Application Ref:	3/2025/0517			 Ribble Valley Borough Council www.ribblevalley.gov.uk
Date Inspected:	~	Site Notice:	3/10/25	
Officer:	BT			
DELEGATED ITEM FILE REPORT:				REFUSAL

Development Description:	Regularisation of construction of a steel portal framed building for use as a pet crematorium facility (sui generis).
Site Address/Location:	Dockber Laithe Farm, Sawley Old Brow, Sawley, BB7 4LF.

NORTH ELEVATION: POST-DEVELOPMENT

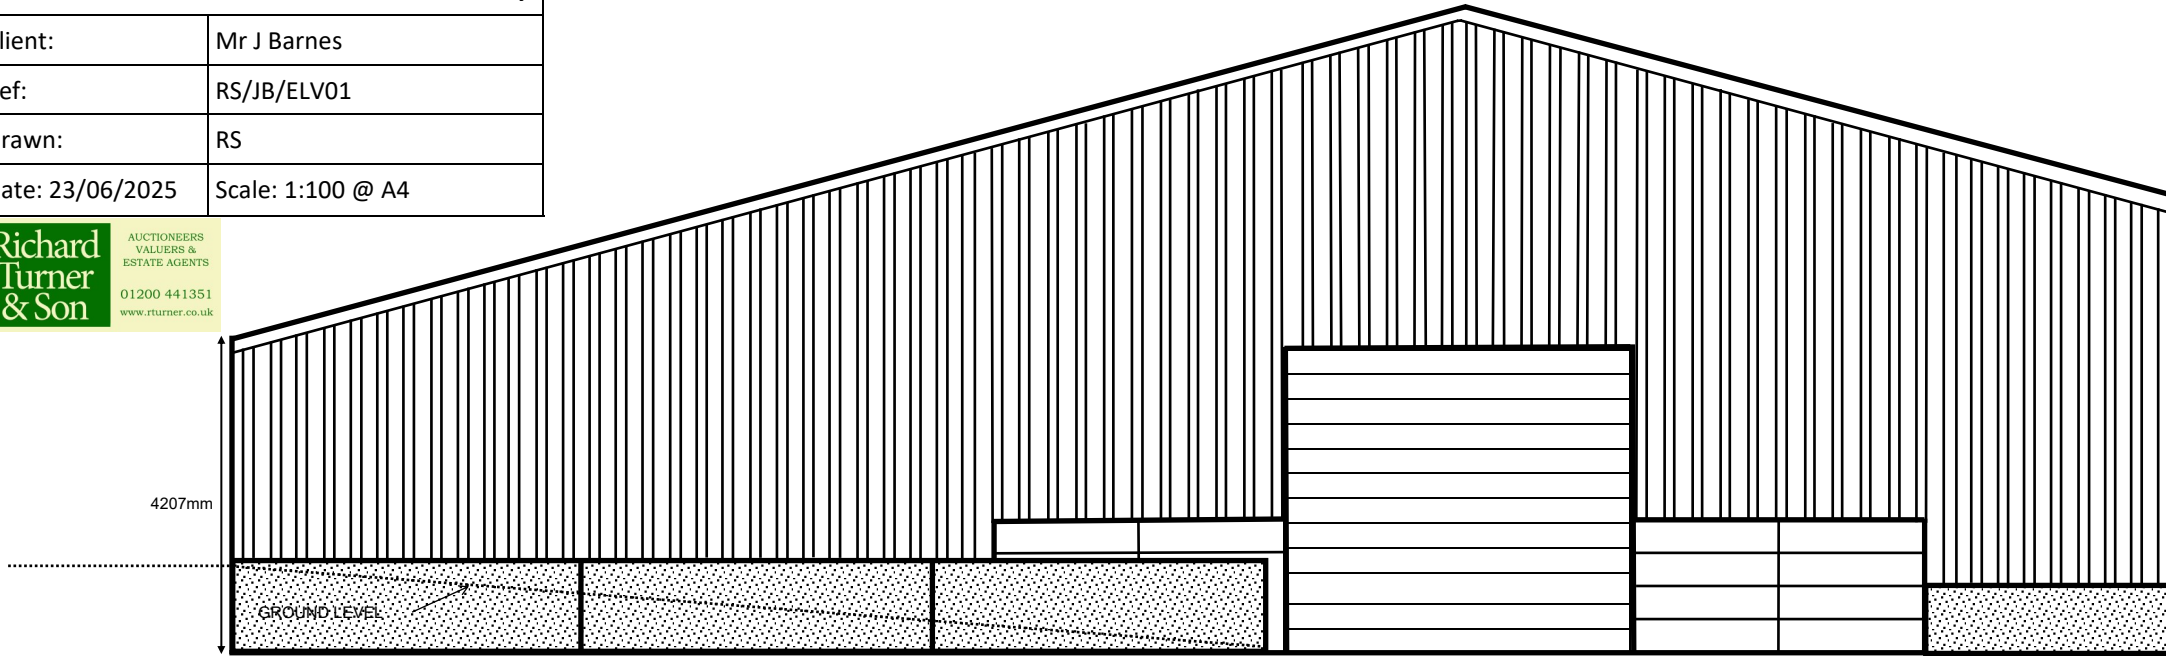
In this instance, whilst the building is small in size when compared to the size and scale of the adjoining building, it is considered that the addition of a flue would be predominantly at odds with the prevailing agricultural character of the site and its immediate and wider rural surroundings and appears more industrial in character. The site is visible from the Public Right of Way which runs along the path to the north of the application building and as such, the visual harm arising from the development is greater, given it is visible from public vantage points within the Forest of Bowland National Landscape.

As such, the design of the building, specifically with the addition of a flue/chimney, fails to protect, conserve and enhance the landscape and character of the Forest of Bowland National Landscape and would introduce inappropriate features which are inappropriate to the rural landscape.

04:	The proposed development, specifically the erection of an industrial flue/chimney, is considered to introduce an alien feature which is not appropriate to the agricultural character of the surrounding landscape, failing to protect, conserve and enhance the landscape and character of the Forest of Bowland National Landscape, contrary to the requirements of Key Statement EN2 and Policies DMG1 and DMG2 of the Ribble Valley Core Strategy and paragraphs 135 (C) and 189 of the NPPF.
